From: Douglas Briggs Partnership [REDACTED]
Sent: 15 March 2019 16:26
To: Andrew Wood
Subject: 6018: Star Plants Application WA/112/18/CLE

RE: 6018: Star Plants Application WA/112/18/CLE

The ADC legal advisors are satisfied that the use is legal however there are three remaining issues relating to various structures on site:

Application Plan SP1.7c

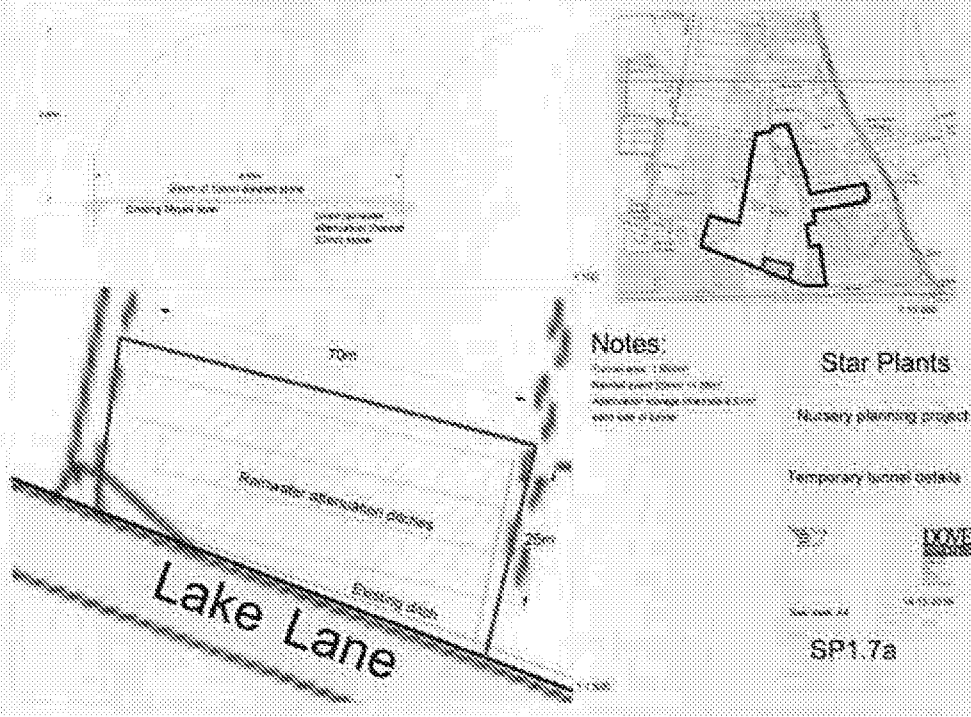
Haygrove 2 Polytunnels: Y/10/17/AG Prior notification under Part 6 for three temporary polythene tunnels. Granted prior approval – decision notice 14.3.2017. Structures must be erected in accordance with the approved details (length, width, height to the eaves and height to the ridge measurements as set out in the decision notice). Evidence: Plan shows 3 tunnels of different lengths and Google earth aerial photo shows tunnels in the position as shown on the plan. It is not clear from the evidence if the tunnels have been erected in accordance with the approved details? Please check the length and width against the scaled plan and determine if the height of the buildings is with is in accordance with approved plans.

We can confirm that the polytunnels have been drawn on the application plan to the same dimensions as the PNO application.

The tree in the 2018 aerial photo makes it difficult to see but the Northern most polytunnel was initially constructed 1 bay short of what was approved, this has since been rectified.

Location Plan 1:5000

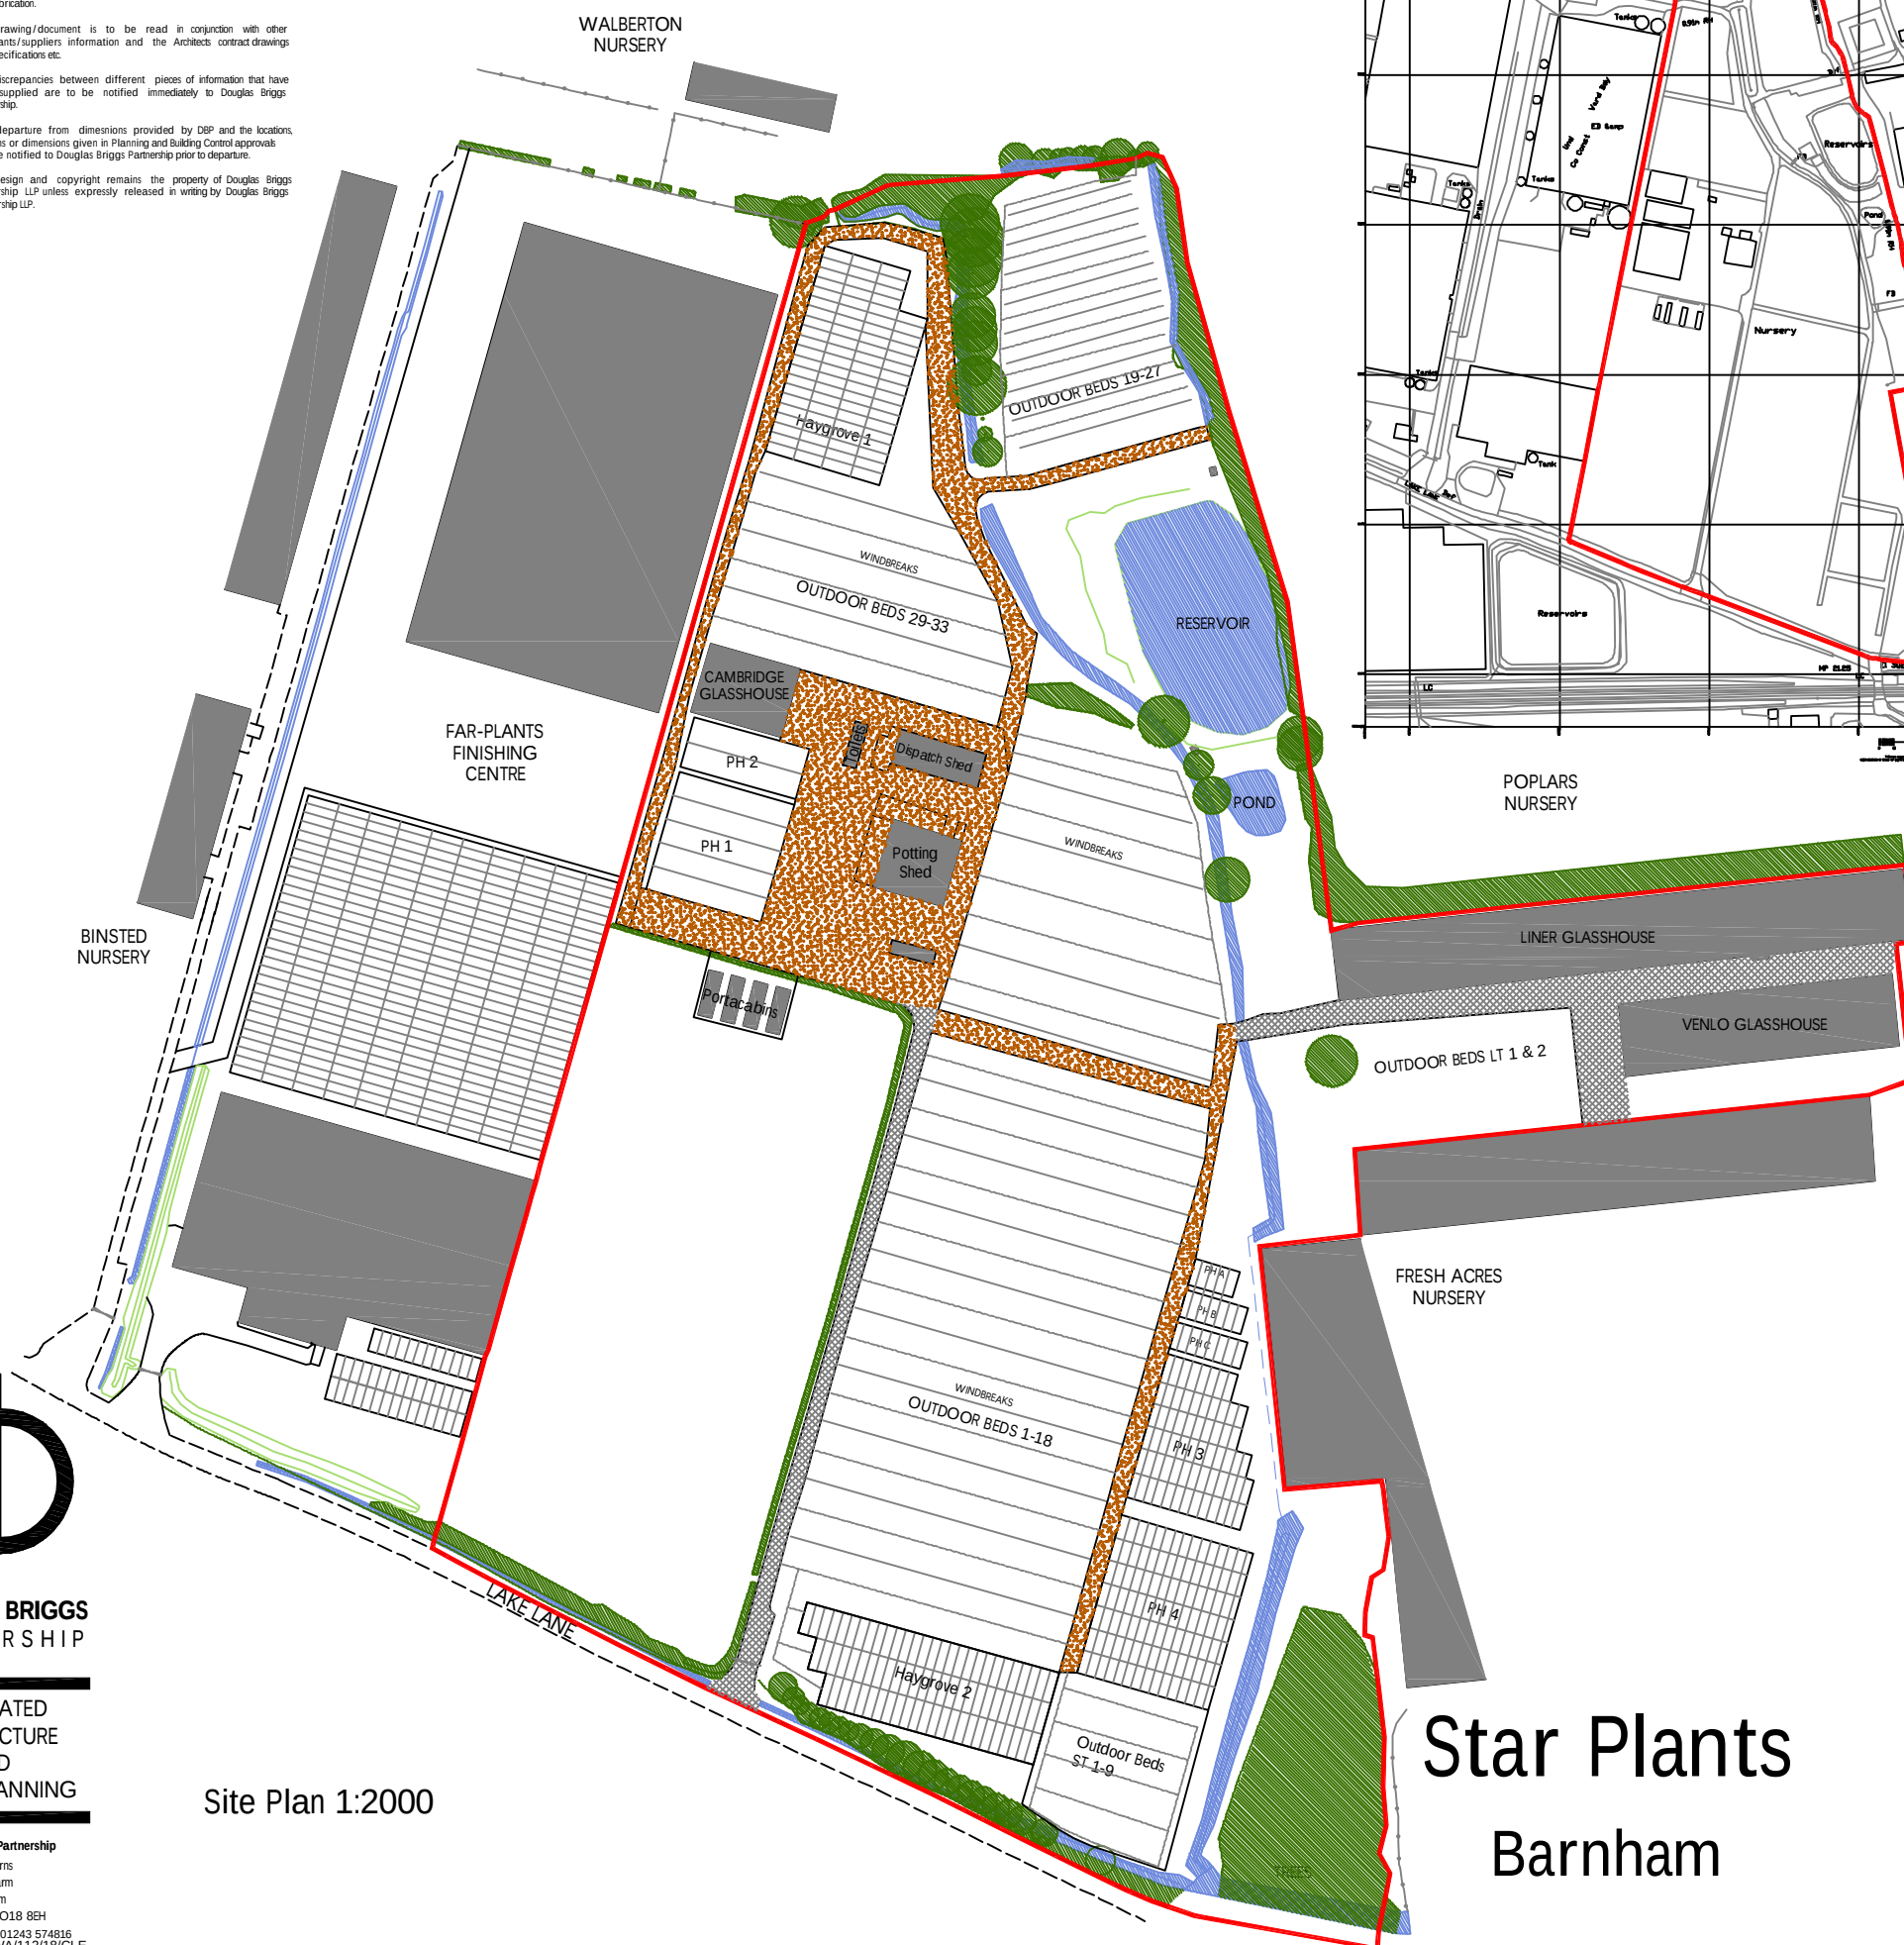
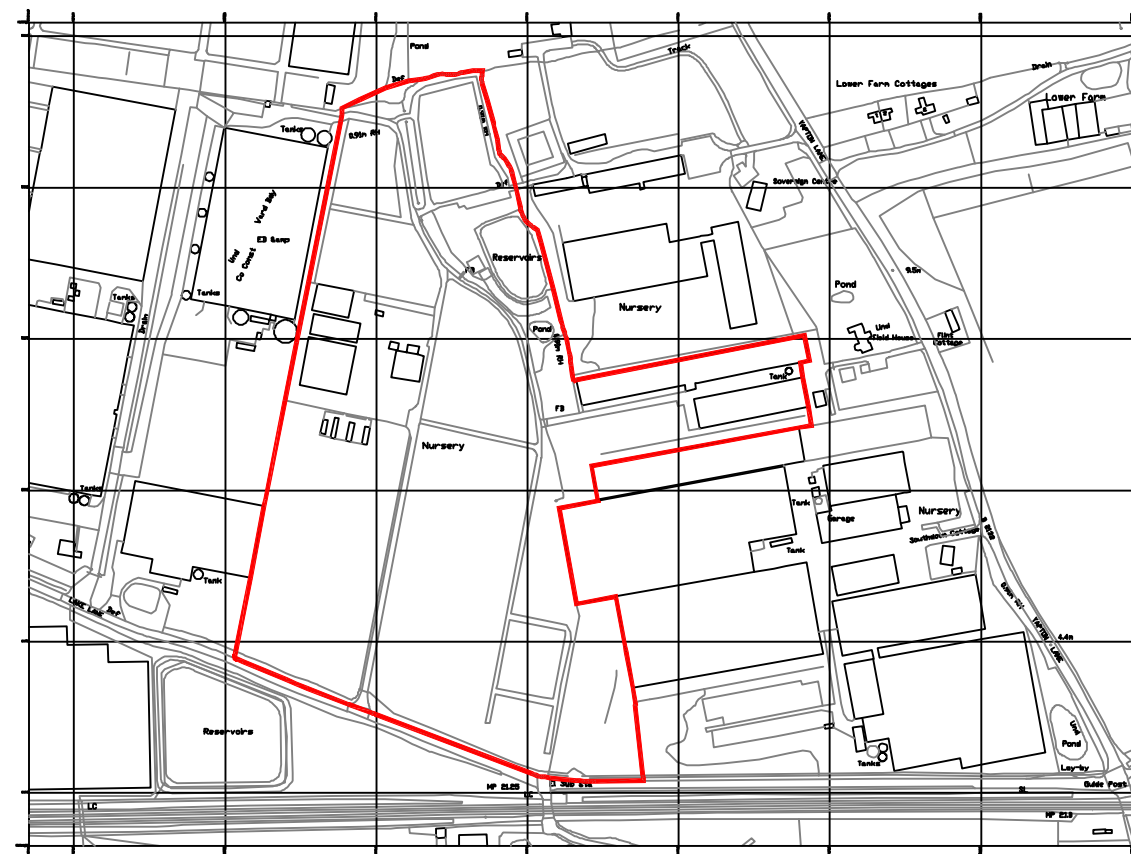
- 1) Can you please confirm via email that you have constructed the haygrove polytunnels in accordance with the approved plans. An assurance will be satisfactory.
- 2) For the avoidance of doubt, can you please add the Walkways between Planted Beds to the Existing Site & Location Plan.

Roads/Farm Tracks: The plan does not identify where the roads are on site. The certificate should be clear where the roads are, so that if any further roads are subsequently built, it is clear which are existing and lawful, and which are new and require prior approval. Looking at the Google Earth aerial photos, I can see a road leading off Lake Lane to the yard, however the table in the Development History refers to more than one road, so clarification should be sought, and you will need to satisfy yourself on the balance of probability as to all of the roads.

2) Please find attached plan 6018-001 rev B amended as requested.

We enclose a revised plan that shows the surfaced roads and tracks.

The plan indicates the tarmac road from the access and concrete track over the bridge to the Linear and Venlo Glasshouses.

The plan also indicates the gravel access tracks around the planted beds
